Re: Framing Issue
Location: Lot 79 Wellers Knoll (249 Old Fashioned Way Lillington, NC)
JDS Project No.: RDU2400276
Date of Inspection: 1/10/24

A representative of JDS Consulting arrived on site to observe the issues reported to us by the client, which are presented, along with our recommendations, in this report.

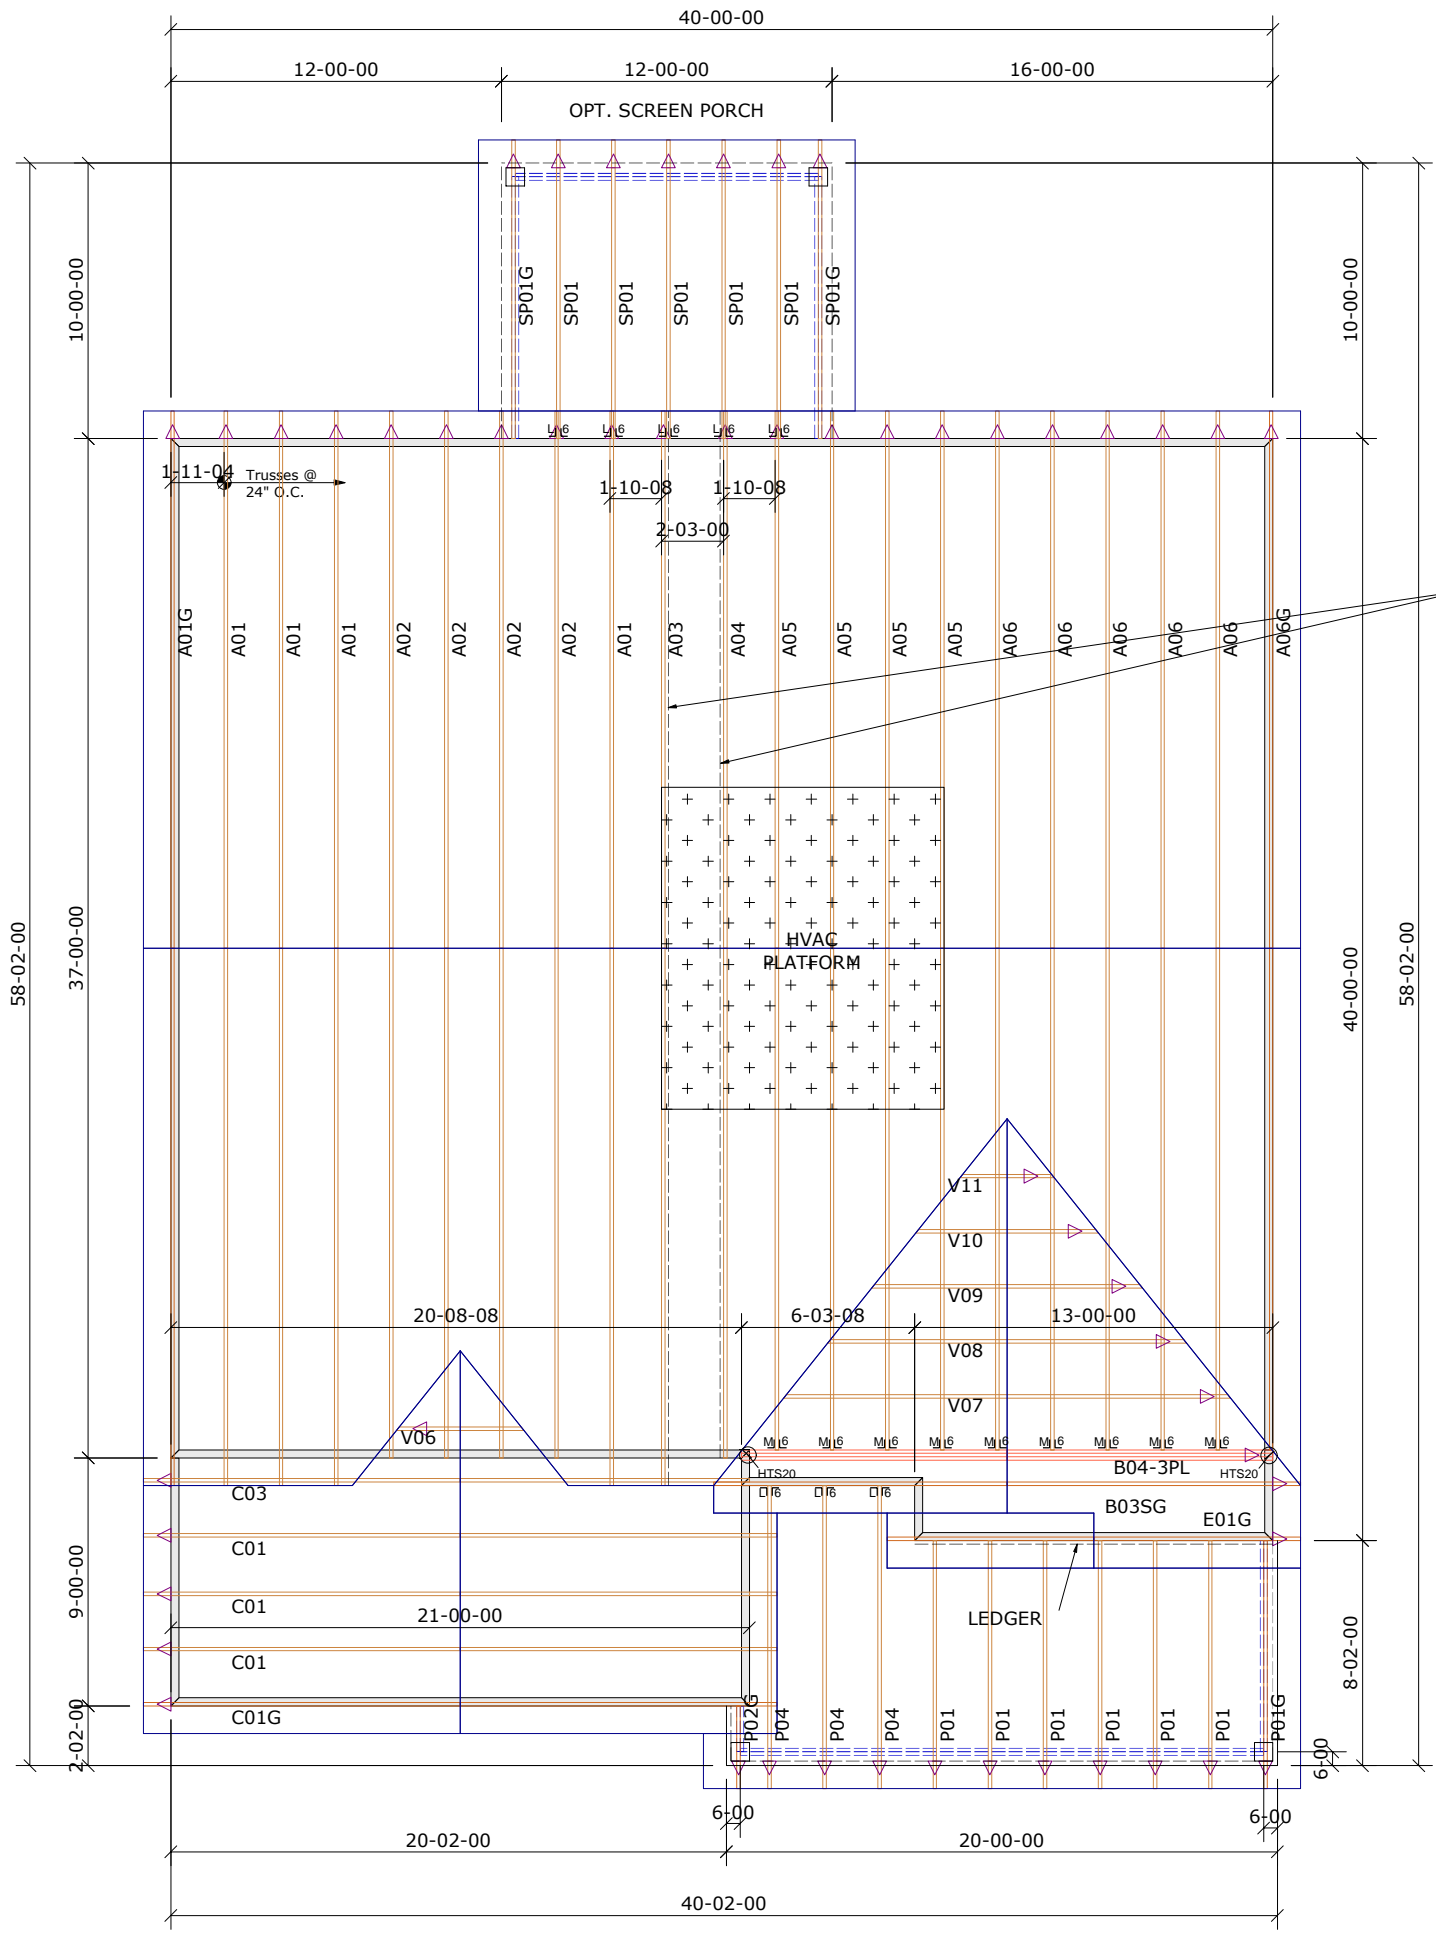
The client has requested evaluation of the hanger at the front bearing end of the A05-2PL hinders the installation of the LGT3 at the left bearing end of the D04-3PL girder truss.

Based on our onsite observation and review the contractor shall remove the 2-ply hanger at the front bearing end of the A05-2PL. Then install the LGT3 hanger in its intended location. Lastly install (1) L30 angle on each side of the front bearing end of the A05-2PL attached to the rear face of the D04-3PL girder truss.
